Addendum #2

**The Parkside Neighborhood Center
and Affordable Housing
Mellen & Grant Streets,
Portland, Maine 04101**

February 20, 2004

SKA-12
rev. 2/25/04
PARTIAL A5.2

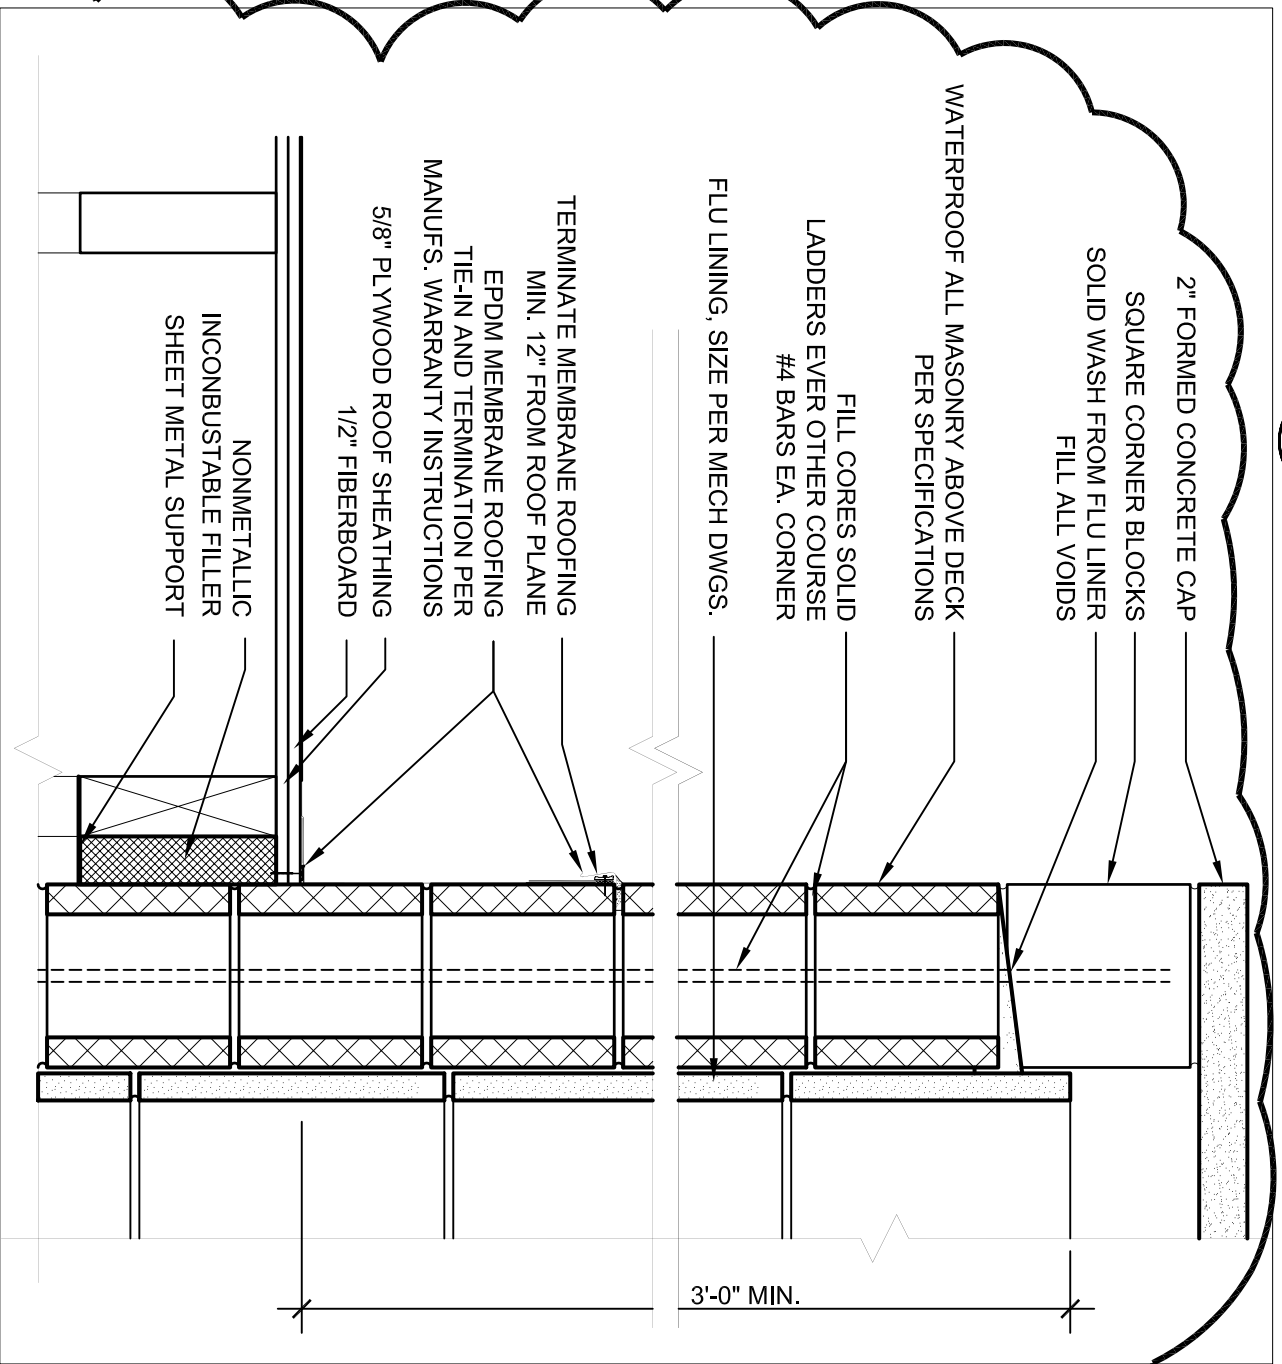
<u>Item</u>	<u>Sheet</u>	<u>Detail</u>	<u>Description</u>
2-12	SKA-12	-	ADD SKA-12, detail 9 to sheet A5.2

What are the requirements for the chimney cap? Any details?

Please see attached sketch SKA-12.

- 2" PRECAST CONCRETE CAP
- SQUARE CORNER BLOCKS
- SOLID WASH FROM FLU LINER
FILL ALL VOIDS
- WATERPROOF ALL MASONRY ABOVE DECK
PER SPECIFICATIONS
- LADDERS EVERY OTHER COURSE
#4 BARS EA. CORNER
- FLU LINING
- TERMINATE MEMBRANE ROOFING
MIN. 12" FROM ROOF PLANE
- EPDM MEMBRANE ROOFING
TIE-IN AND TERMINATION PER
MANUFS. WARRANTY INSTRUCTIONS
- 5/8" PLYWOOD ROOF SHEATHING
1/2" FIBERBOARD
- NONMETALLIC
INCOMBUSTIBLE FILLER
SHEET METAL SUPPORT

BUILDING A
A1.3

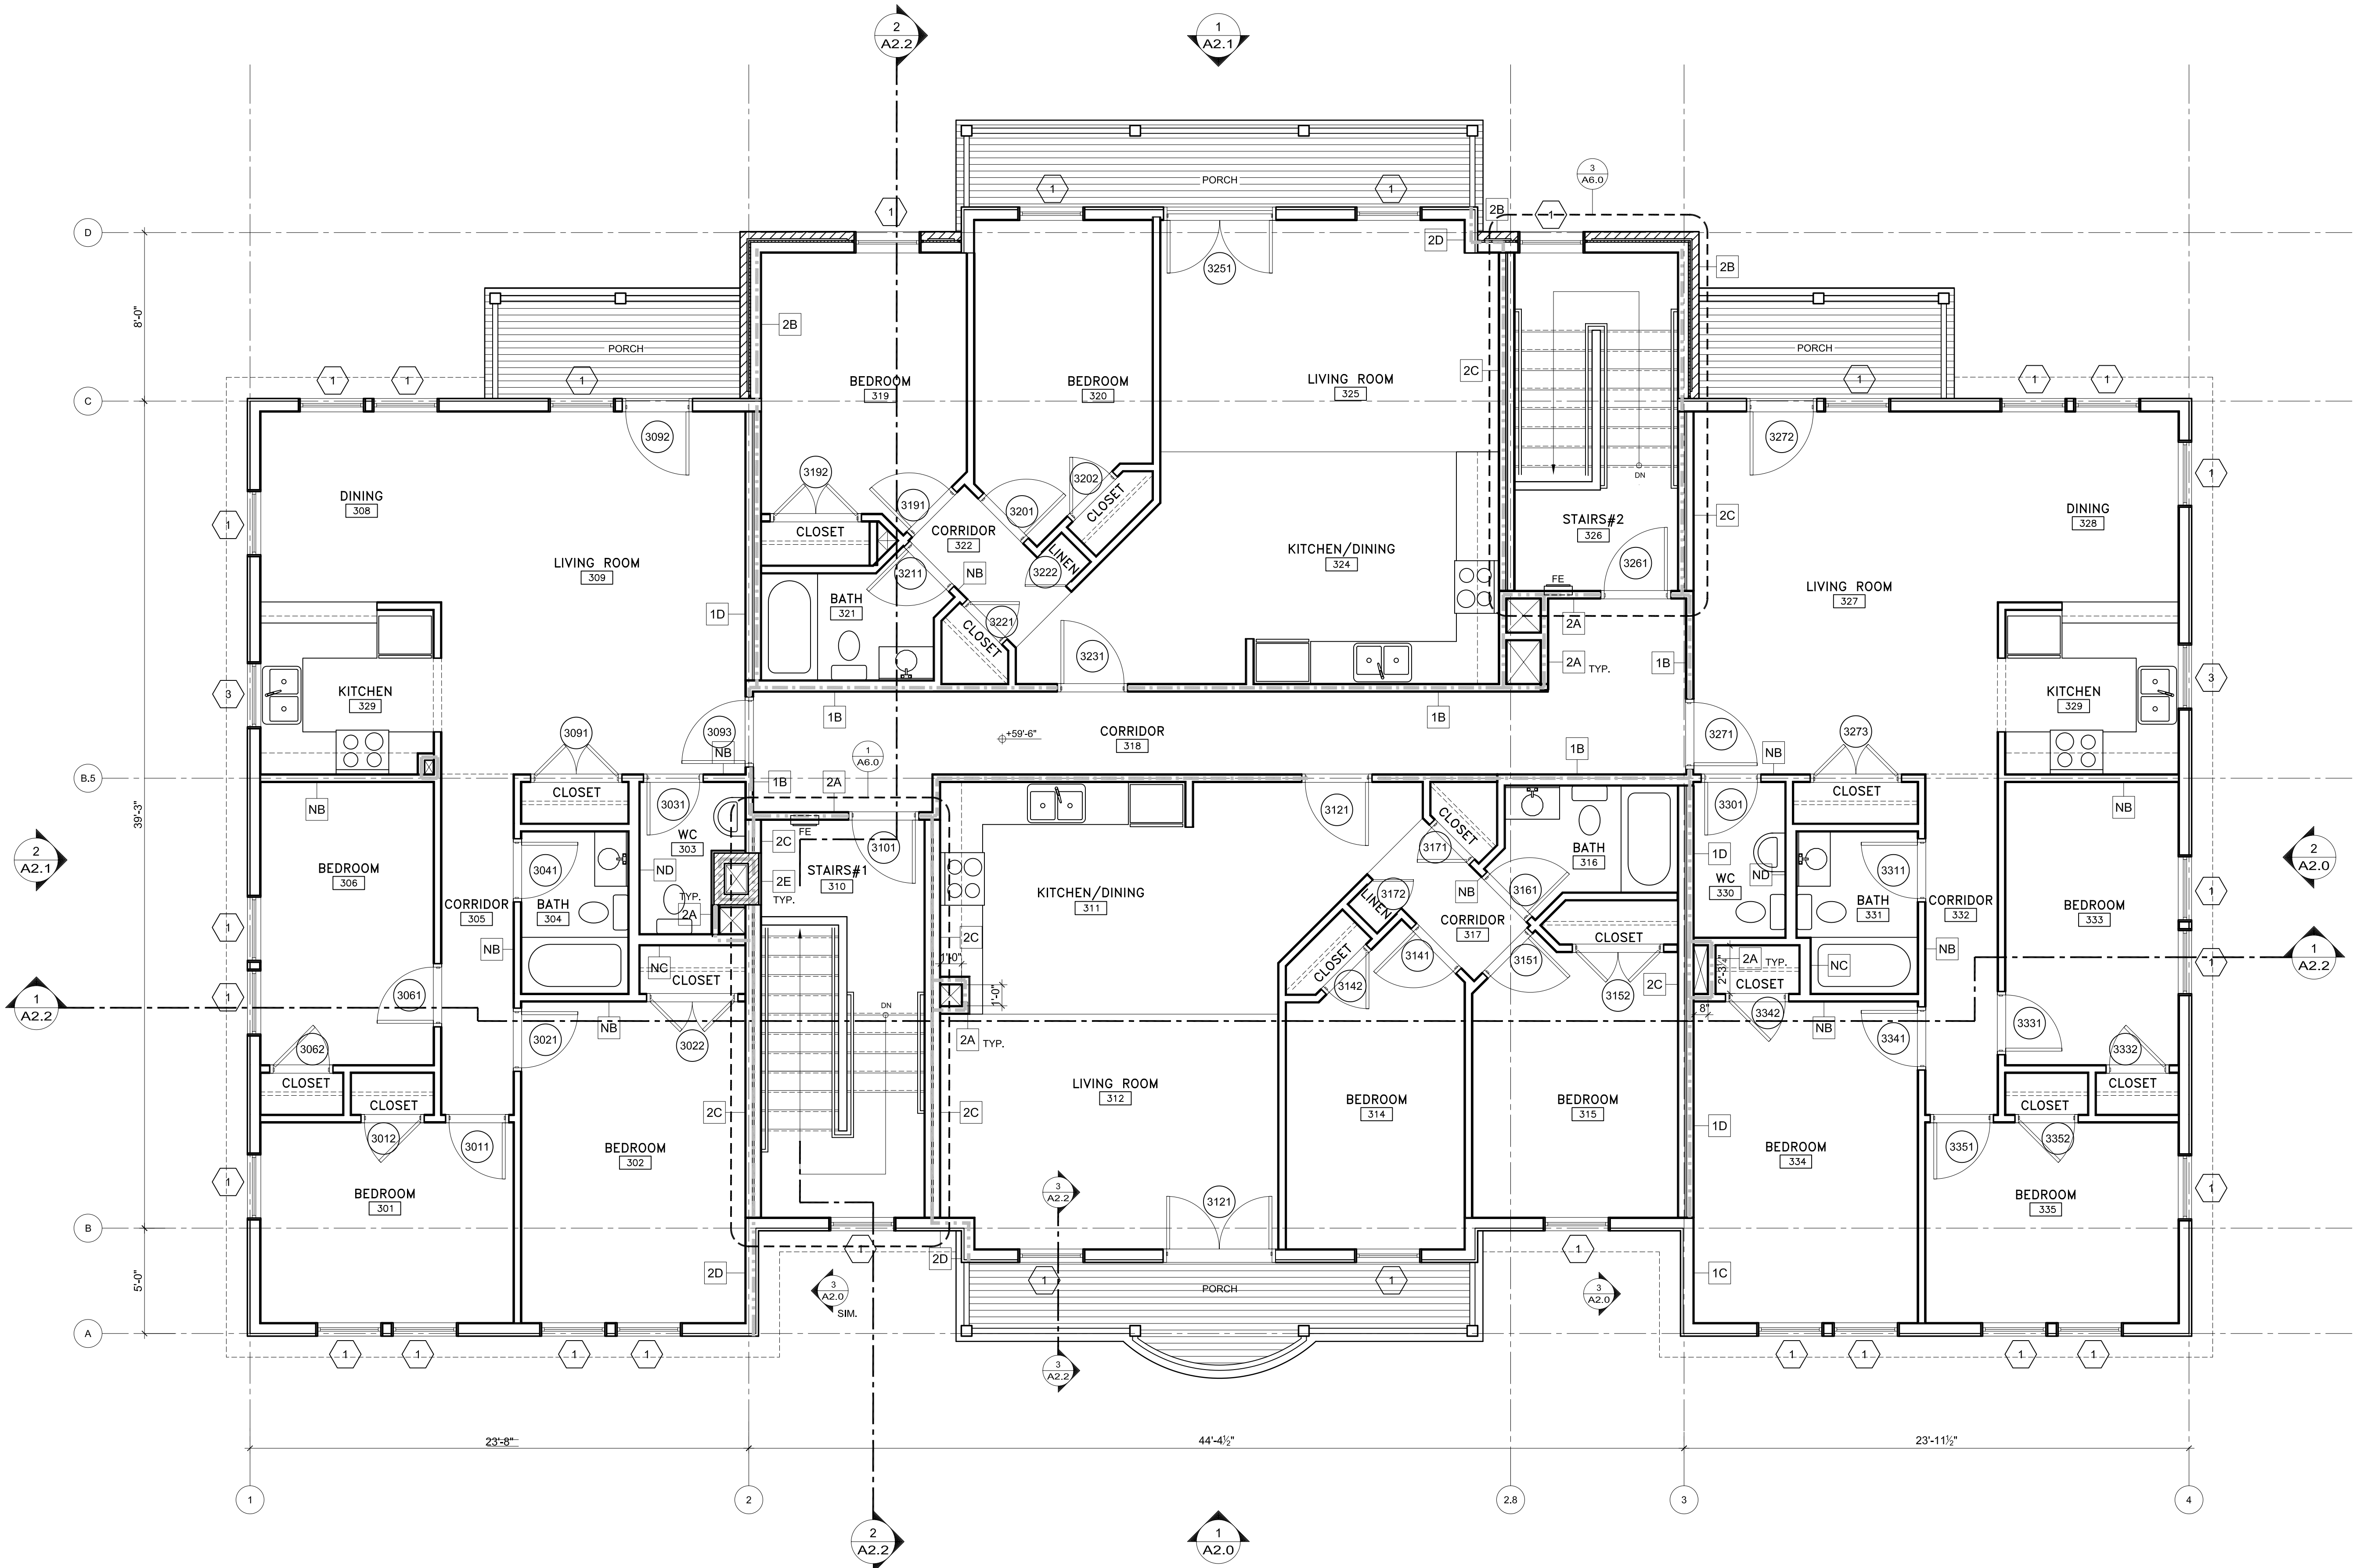
Building B, South elevation, A2.0 #1 shows single windows in rooms 301 & 328, floor plan A1.3 indicates 2 windows each, which is correct?

The floor plan is correct, elevation #1, A2.0 should be revised to indicate double windows.

BUILDING A
A3.0

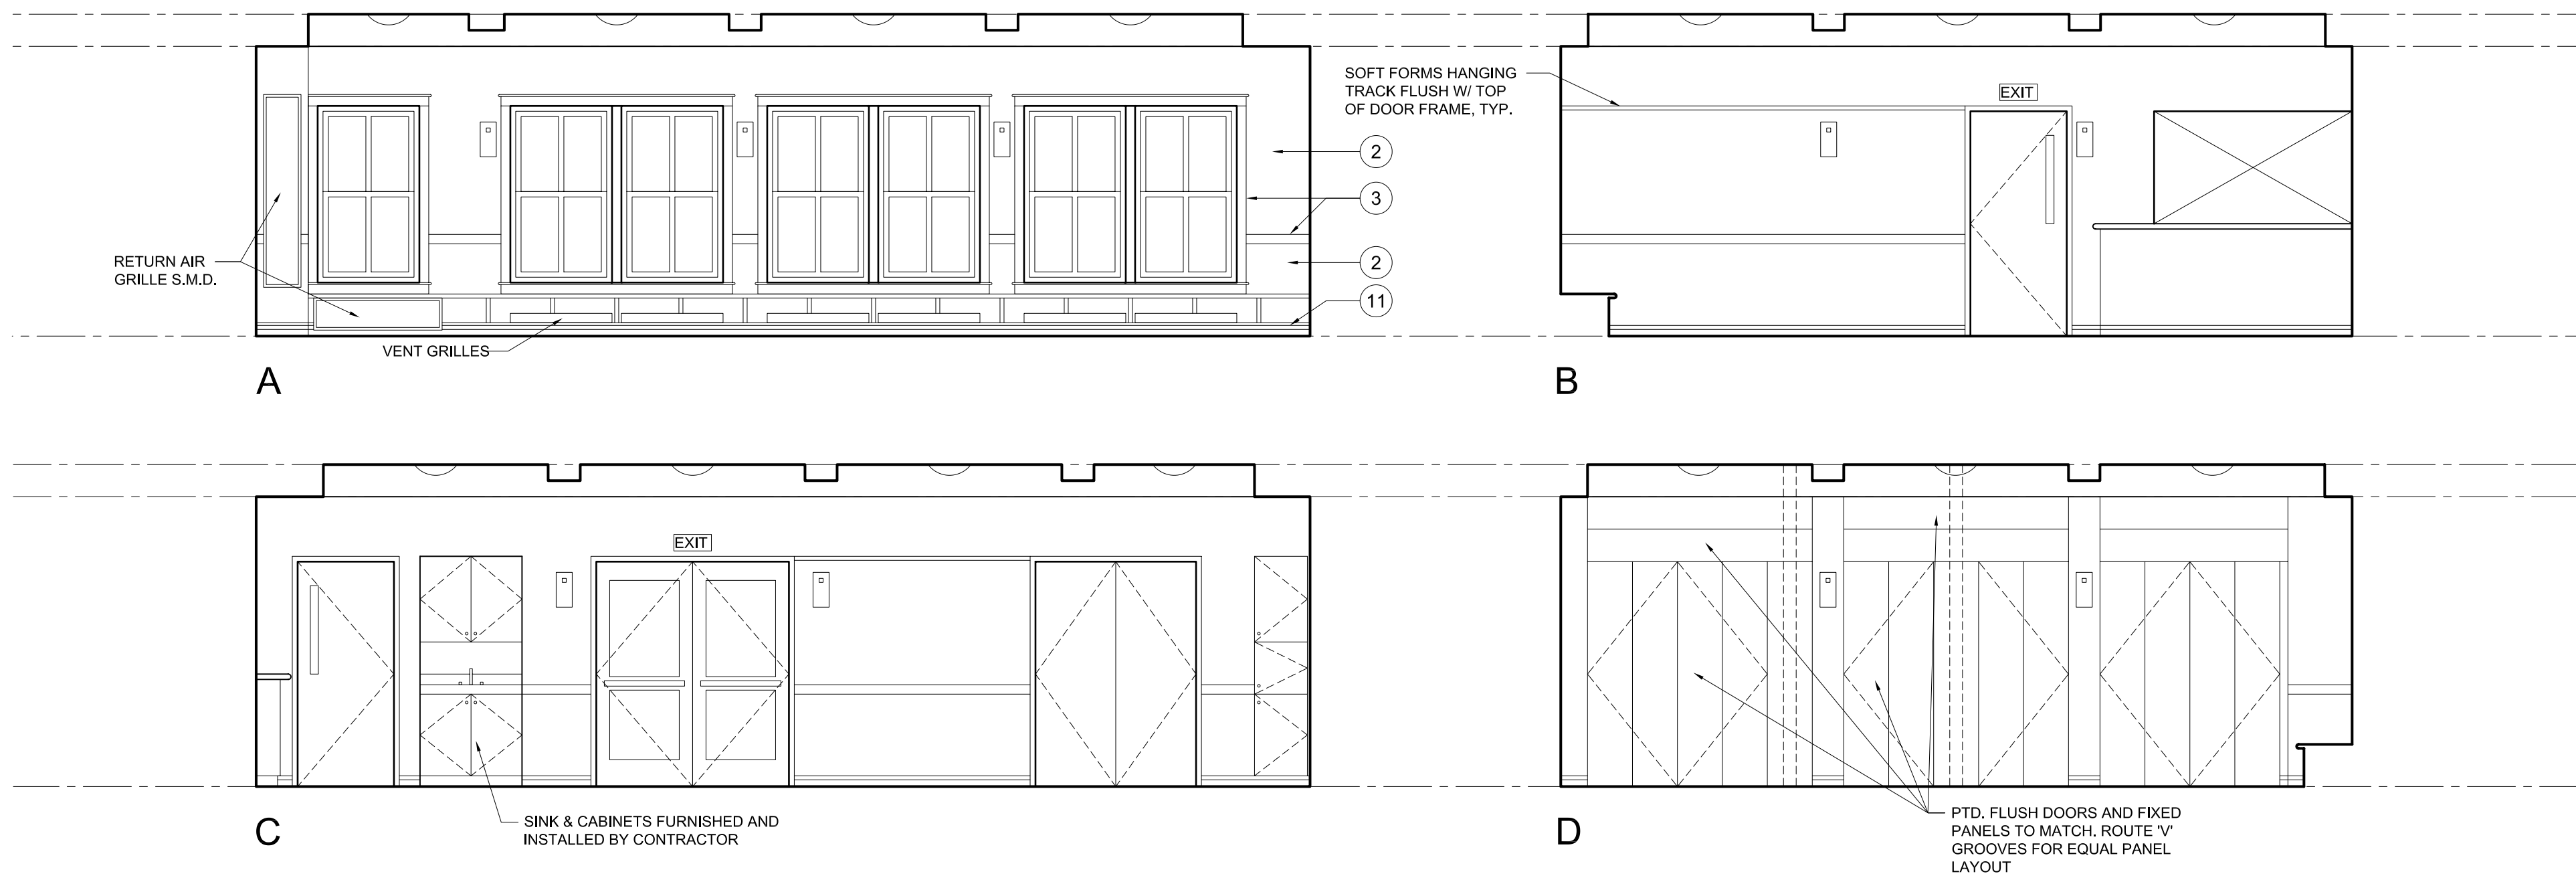
- 2-26 QUESTION
Please provide additional information for the linoleum counter indicated on sheet A3.0, # 3 C & D.
- ANSWER
Linoleum should be from the Forbo 'Real' line, 2.0 mm thick, color from the standard range. Edge should be clear finished maple with a full bullnose profile

5 KITCHEN, ROOM # 207
1/4" = 1'-0"

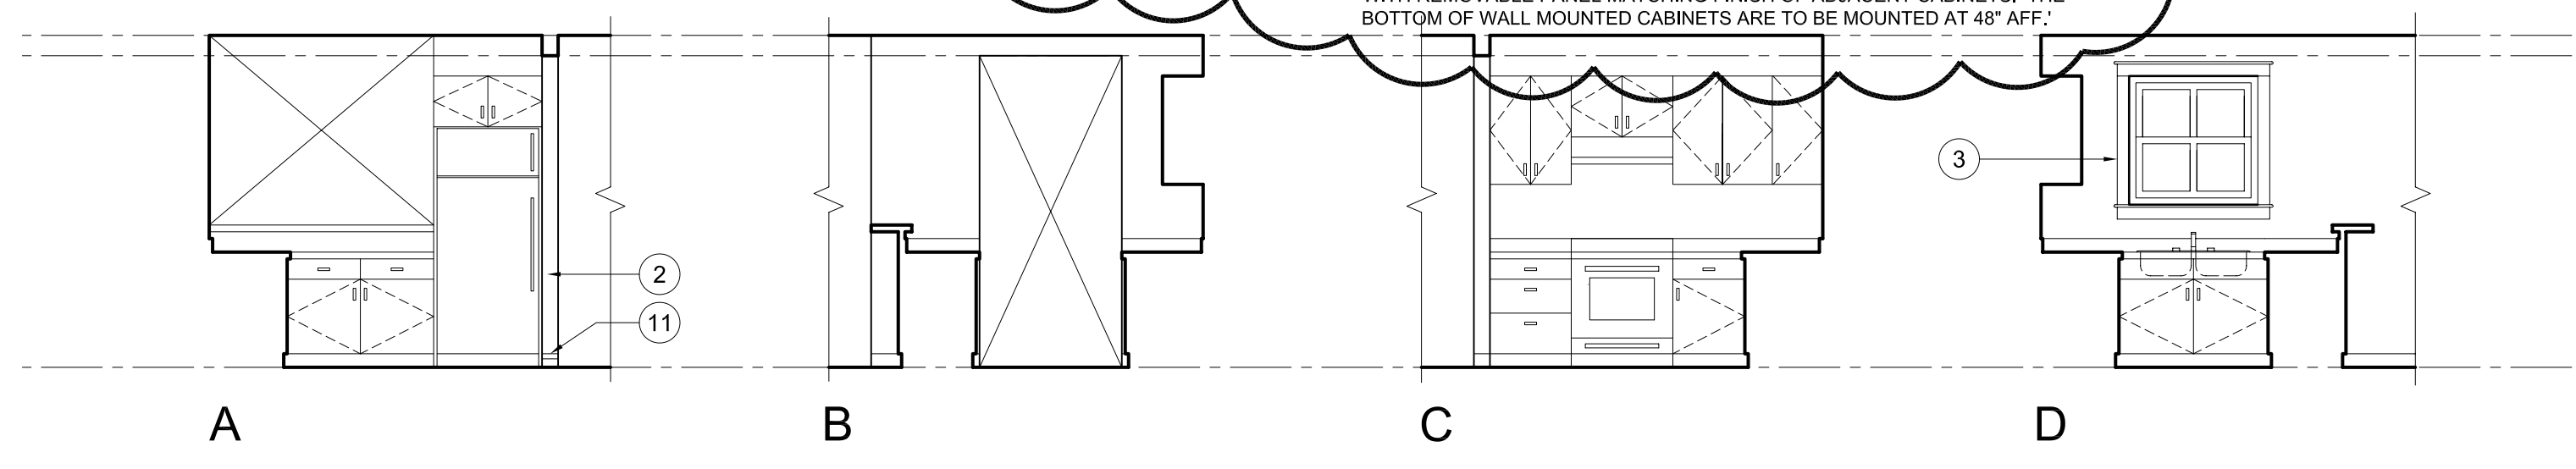
- 2-28 QUESTION
On sheet A3.2, # 5 B D, should there be a framed wall below the raised counter top?
- ANSWER
Yes, a framed wall should be included in the counter depth to support the counter. When not end supported brackets should also be provided for sufficient support.
